**Consultation Response from KC,
Trees**
2024/93221 Parkwood Mill, Stoney Lane, Longwood, HD3 4ZQ
Erection of 5 dwellings and associated works (within a Conservation Area)
Date Responded: 22/01/2024
Responding Officer: JD
Responding Ref: 04/98

**PROPOSED SITE PLAN**  
SCALE 1:200

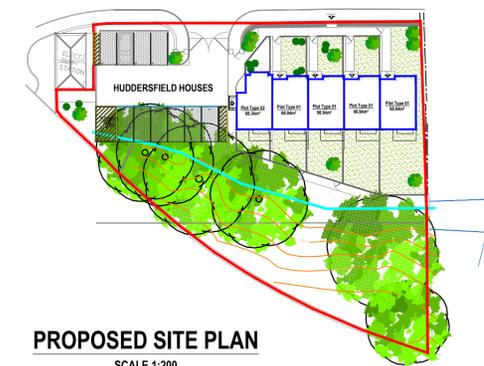
Whilst the proposals appear to be achievable without any direct impact on the trees there are concerns that due to the location of these trees a large portion of the site will be cast in shade though out the day. The proposals show very limited sized gardens which will rarely see daylight due to the trees being on a raised bank and situated to the south. This can lead to residents putting pressure on the council to have these trees worked on or even removed. The proposed gardens and car park is also likely to see seasonal detritus falling from the trees which in turn leads to even more pressure to have the trees removed or worked on.

There is a need for an Arboricultural Impact Assessment (AIA) to be produced showing the proposals overlaid with the tree information of the site. This will help determine the exact distances the buildings are from the trees and will make it easier to assess the true impact the proposals would have on the adjacent trees. There is also a need for the AIA to show the canopy shade through out the day so this impact can be seen.
